Eastcote and Northwood Hills United Reformed Church, Joel Street, Northwood Hills
Pre-Application - Supplementary statement 20 May 2021

LBH Conservation Officer's comments in **bold**

Theis + Khan's comments in regular

project		
eastcote and northwood hills URC		
drawing		
ground floor plan proposed		
scale	date	
1:200@A3	jul 19	
job number	drawing number	revision
1132	110	p11

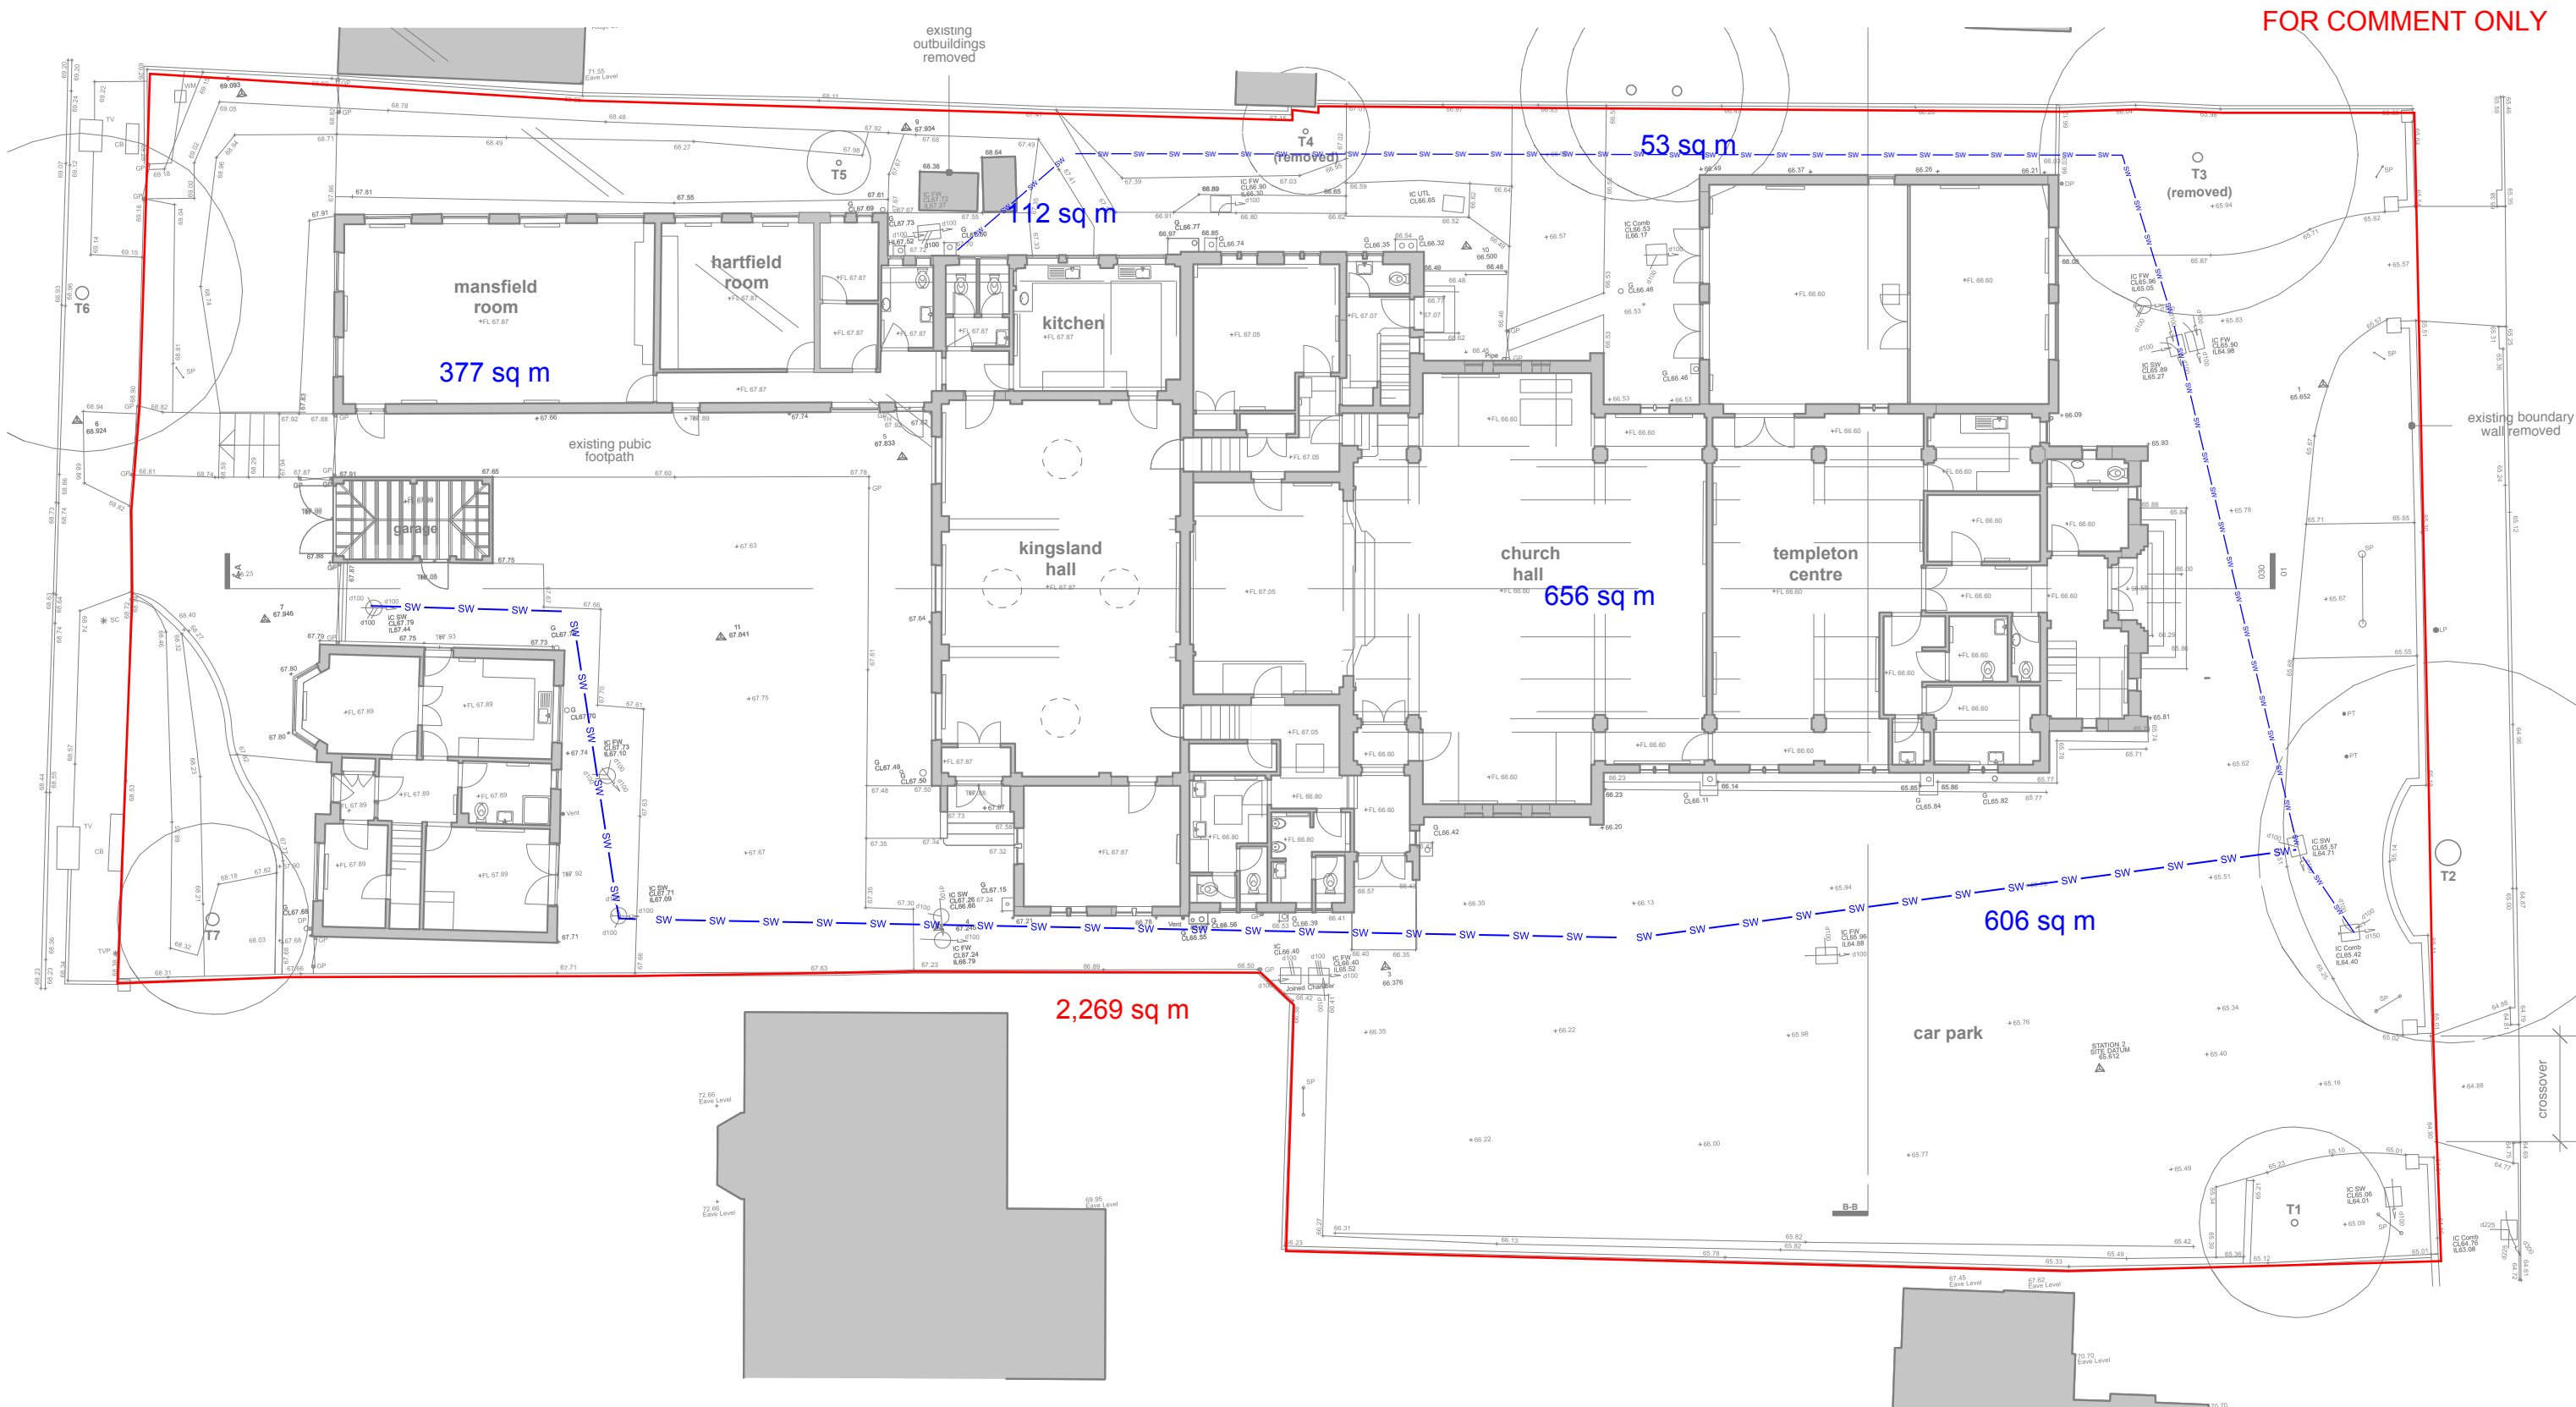
'There would be some concerns in regard to the alterations to the appearance of the church. The existing brick facade is a characteristic feature of the building, and loss of the small original windows would be disappointing.'

'The insertion of large glazed openings would dramatically alter the appearance of the original building and significantly unbalance the symmetry of the front elevation.'

'It is strongly advised the symmetry of the existing building is maintained. The fenestration arrangement to the side addition creates a boxy built form, somewhat detracting from the original church building. Brick is a defining characteristic of the existing building it is advised the extent of glazing particularly at first floor level is reduced.'

'The proposed rendered section would introduce a new material finish to the site. Whilst views may be limited due to the proposed locations along the side elevation and to the rear of the existing building it would still be significantly contrasting against the natural tones of the brickwork. Ideally brick should be used across the site.'

'It is encouraged that the flat roof is upgraded to a green roof, adding further greenery to the site.'

- We agree that brick is a defining characteristic of the existing building and have used the brick corbel detail seen over the existing arched window on other parts of the new elevation as a reference to brick detailing of that era and to visually tie the elevation together.

- As explained above, one of the main elements of the brief was to create an open and welcoming elevation to bring light and views into the building. We have therefore inserted large areas of glazing to positively create a dramatic change to the elevation in order to send out a clear message to the community that a new hub is open and ready to welcome them.

- We agree that the symmetry of the elevation is important. The retained church elevation remains symmetrical even with the larger windows. The extension to the north side of the church is deliberately asymmetrical as this references the existing Templeton Hall, creates a visual step up to the neighbouring block of flats and maximises the space available in the car park. The use of a matching brick binds it to the existing church elevation allowing the existing main church entrance to remain as the most important central feature whilst creating a fully glazed community café façade to the terrace at ground floor and a new community hall at first floor. The full width glazing at first floor level will allow light and views into the hall enlivening the space both for people using it and for people walking past the centre and looking in, a fundamental part of the brief.

- It is agreed that ideally brick should be used wherever possible. However the insulated render has been proposed for the following reasons:
 - It is self-finished so would not need to be repainted.
 - It is white coloured to maximise light into adjacent spaces.
 - It is more economic and affordable than new brickwork and is within the church's current construction budget.

- It is an ambition of the church to install 'green' flat roofs if the budget allows.
